**From:** Laura Gibbons  
**Sent:** 21 May 2019 16:13  
**To:** Zac Denton  
**Subject:** FW: Apple Barn Cottage - CM/5/19/HH  
**Attachments:** RE: Apple Barn Cottage - CM/5/19/HH; G2 calcs revised -100.pdf; G2 calcs revised -10.pdf; G1 calcs revised.pdf; 2017-SK4 surface water drainage.pdf

**From:** David Fuller [REDACTED]  
**Sent:** 20 May 2019 16:29  
**To:** Zac Denton  
**Cc:** Laura Gibbons; [REDACTED]  
**Subject:** Re: Apple Barn Cottage - CM/5/19/HH

Project			
Apple Barn Cottage			
A259			
Climping			
Client			
Alex Stephens			
Drawing Title			
Surface Water Drainage			
© This drawing is copyright. It may not be copied or reproduced without written authority.			
Scale	As shown	At original	A3
Drawing Number	2017/SK4	Revision	-

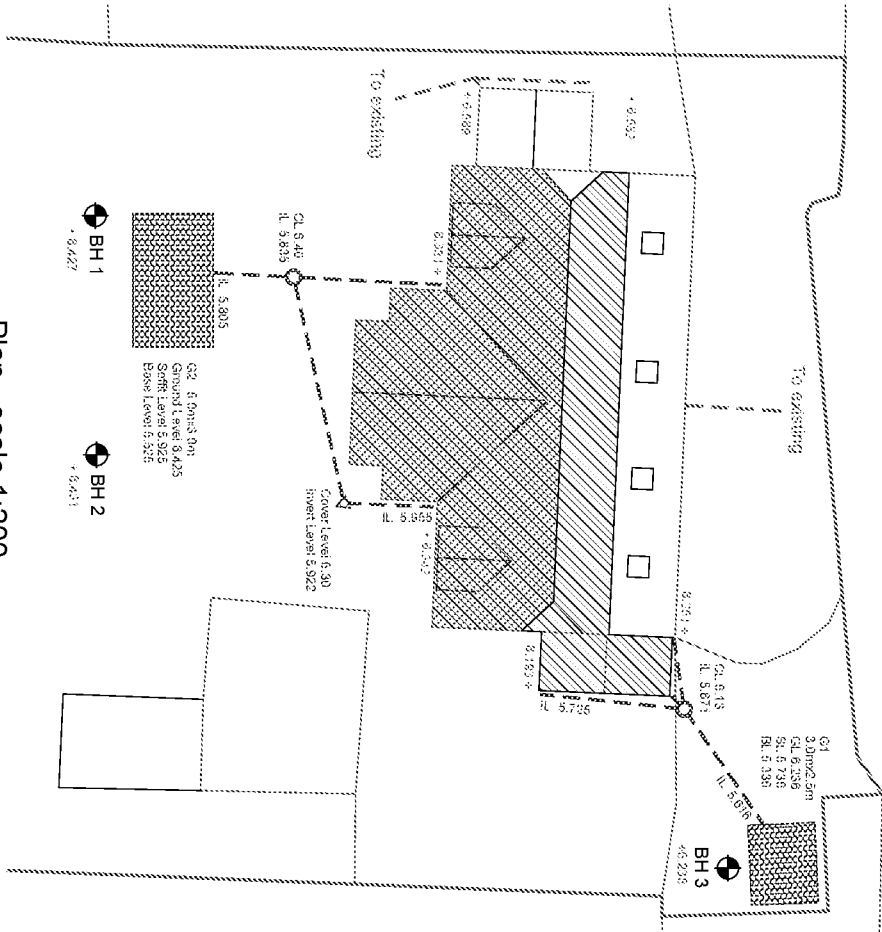
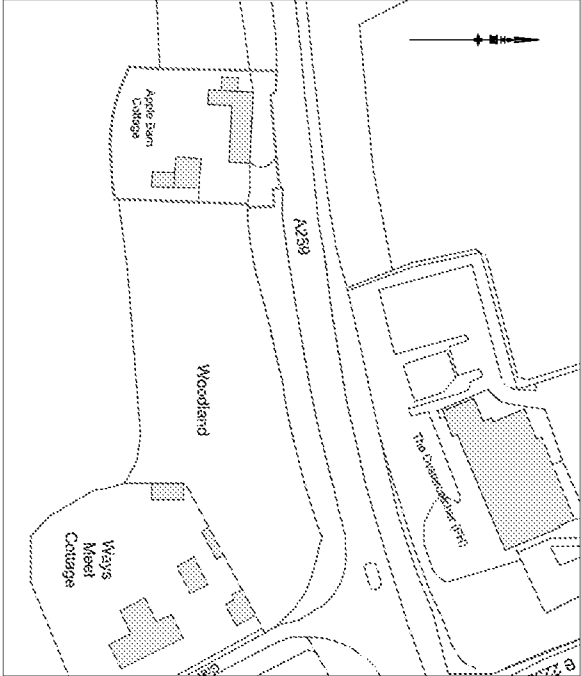
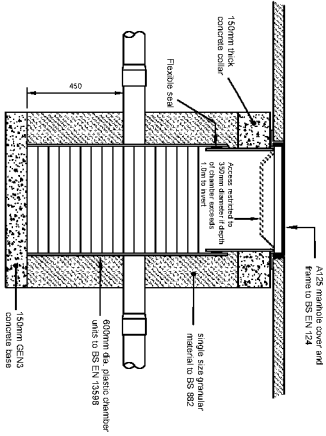
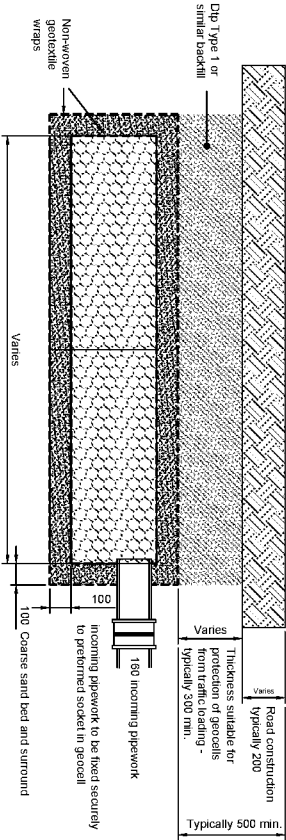
*Further information has been provided about the depth of infiltration tests and the rates at each testing location. I would like to see the test result from BH3 used in design of G1 soakaway. And the infiltration rate of BH2 at 929mm depth used in the design of G2 soakaway. These results are those that most accurately reflect the location and depth of the proposed soakaways."*

Please can we get the surface water drainage calculations supplied to support the proposed design.

Please can the applicant also submit further details of the infiltration testing. I note that the layout states that an average rate has been used in design. Please can the depths of infiltration testing and results be supplied to ensure that the infiltration rate used in design is appropriate.
